Application Ref:	2025/0851			 Ribble Valley Borough Council www.ribblevalley.gov.uk
Date Inspected:	23/05/2025	Site Notice:	23/05/2025	
Officer:	EP			
DELEGATED ITEM FILE REPORT:				APPROVAL

Development Description:	Proposed single-storey extension to rear and landscaping works.
Site Address/Location:	3 Westfield Close, Whalley BB7 9XG.

SHEET: PROPOSED PLANS &
ELEVATIONS

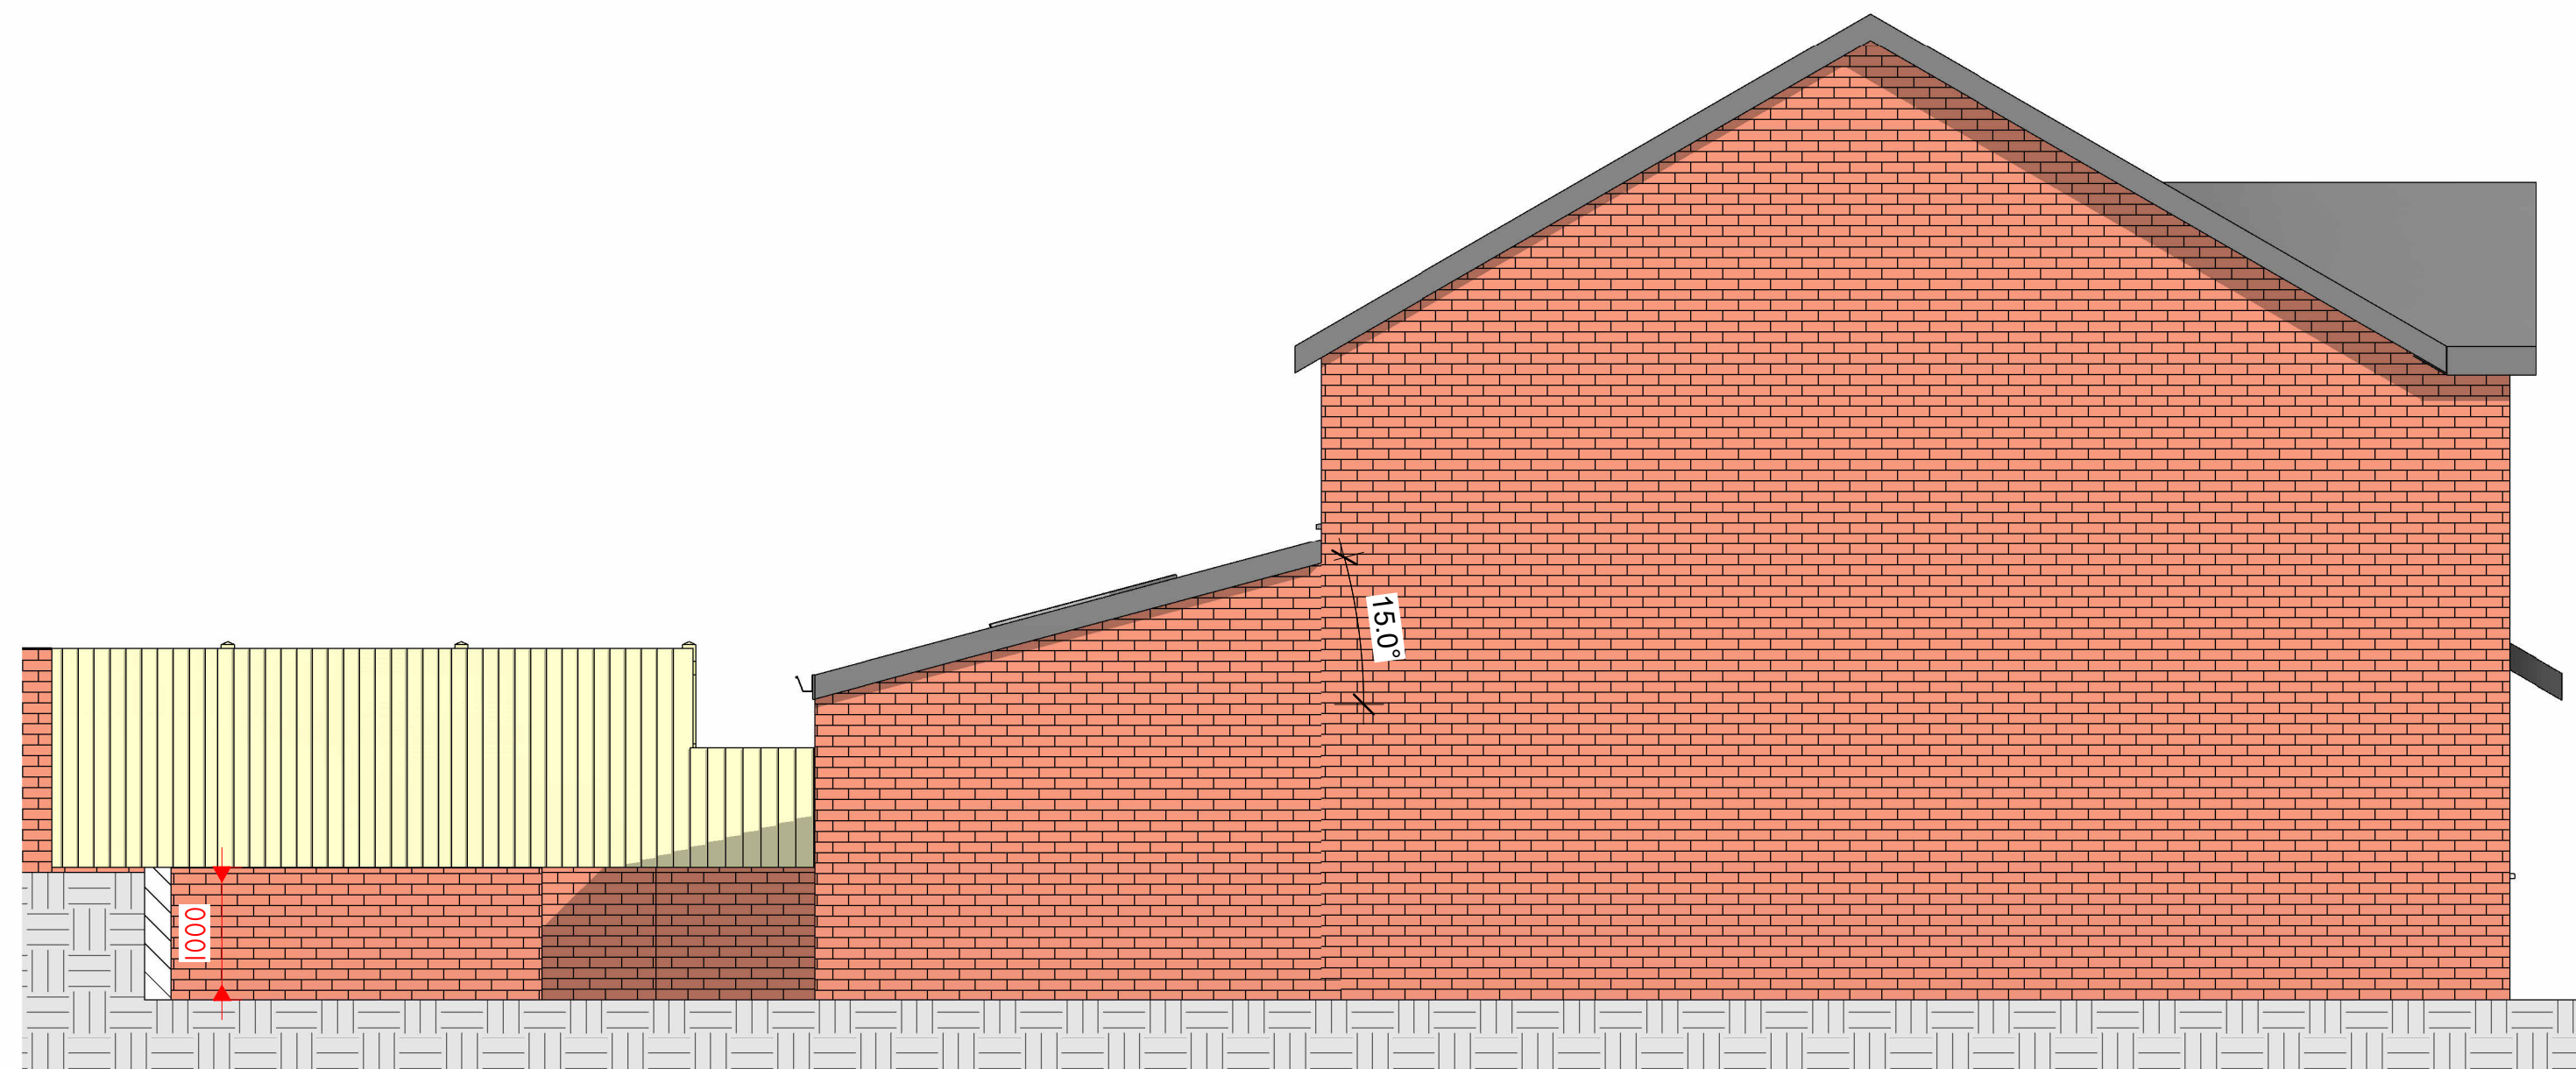
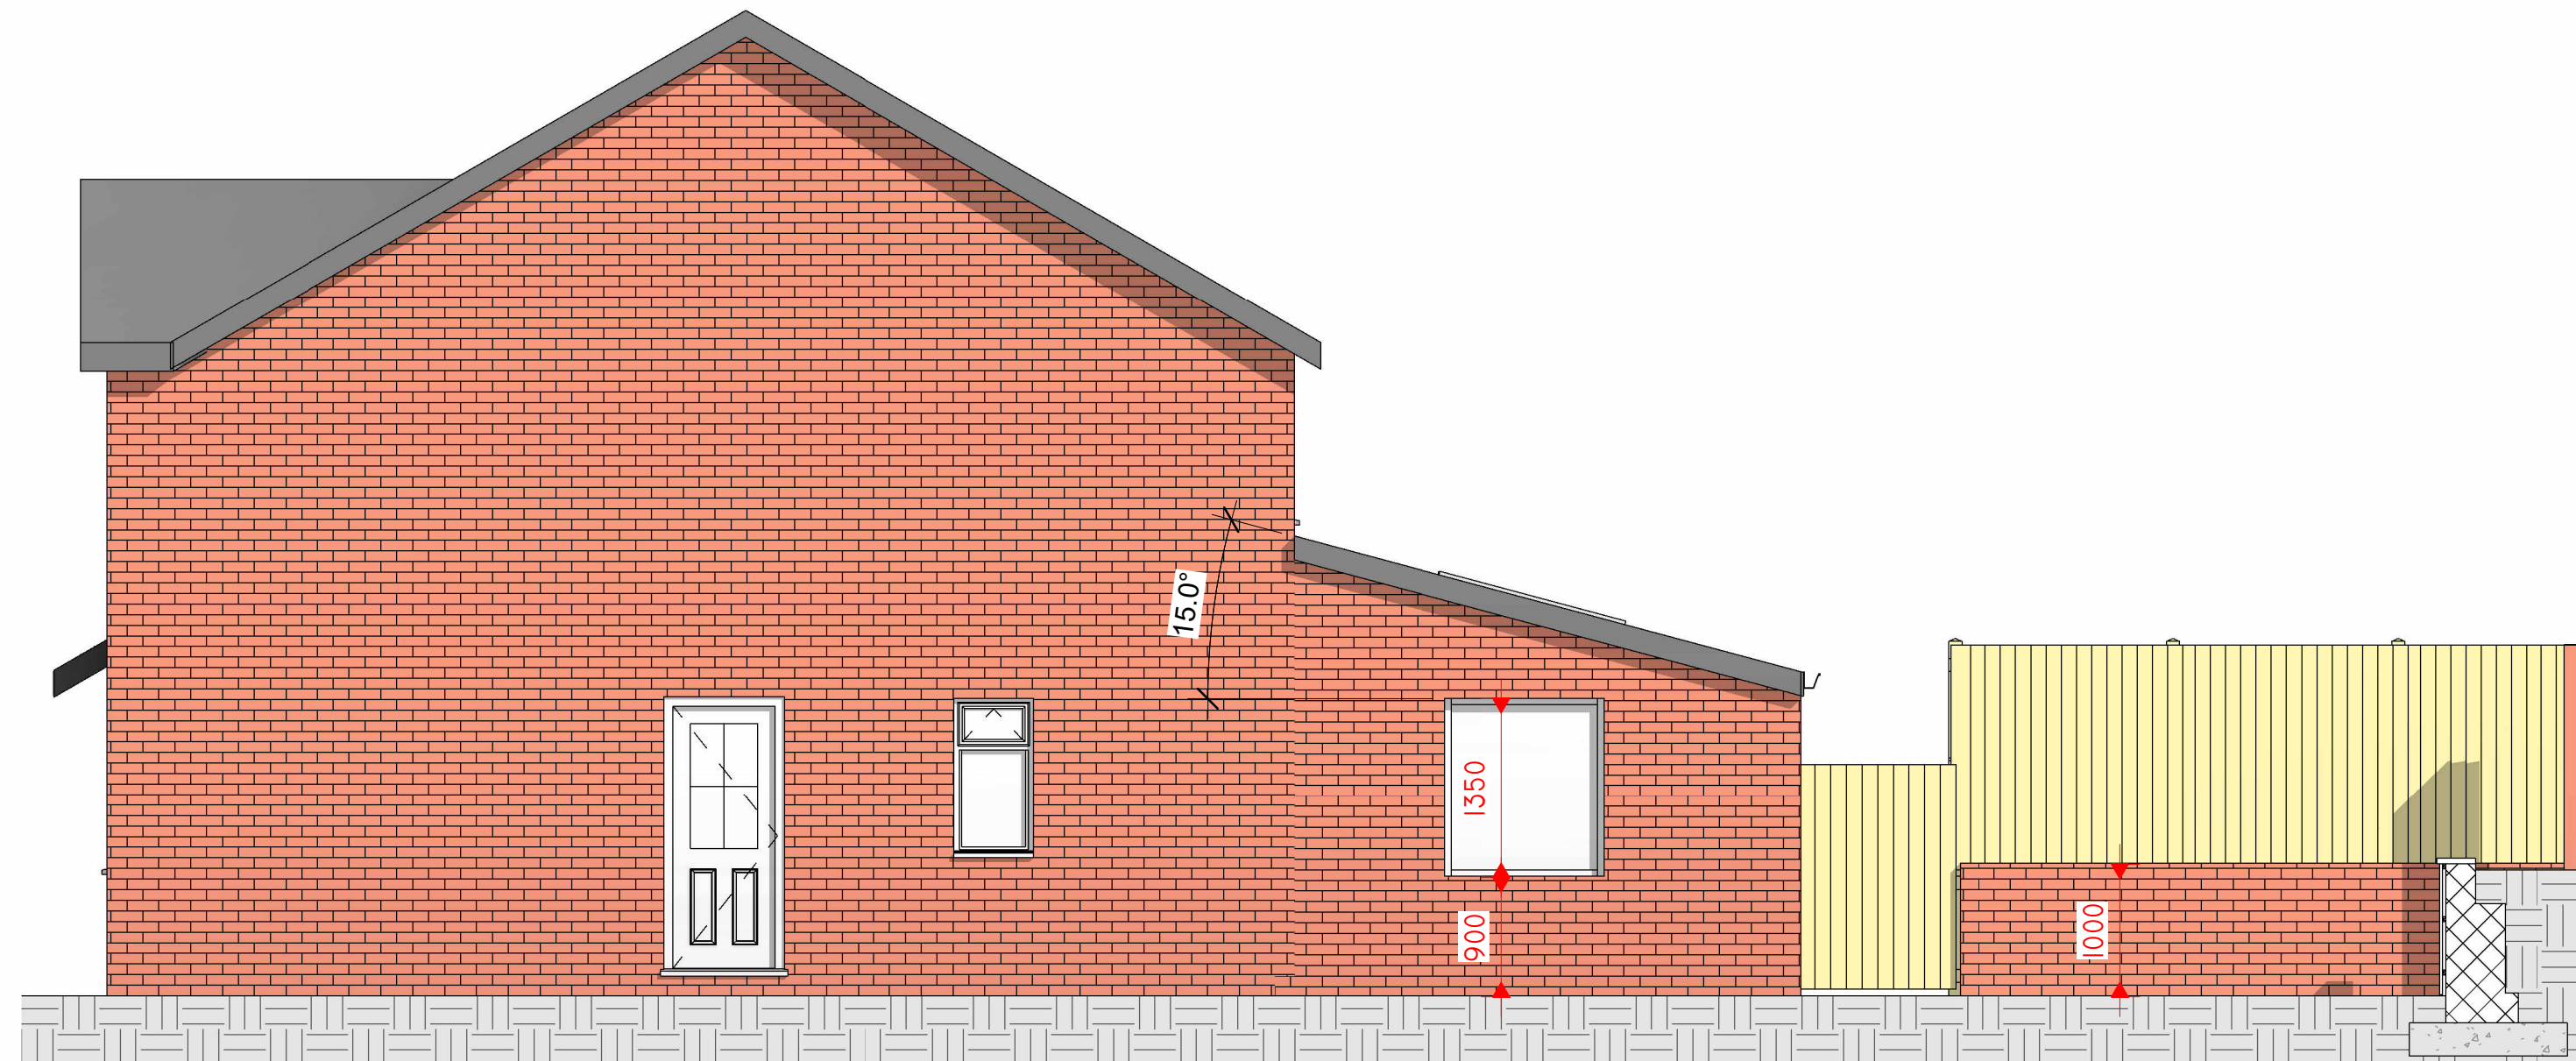
It is noted that a much higher and longer extent of fencing has been depicted to the side (east and west) boundaries on the proposed plans than shown on the existing plans. Boundary treatment above 2m could require planning permission. For the avoidance of doubt, this has not been included in the description or any specific details provided in terms of materials and heights and therefore no assessment or approval of this element has been undertaken.
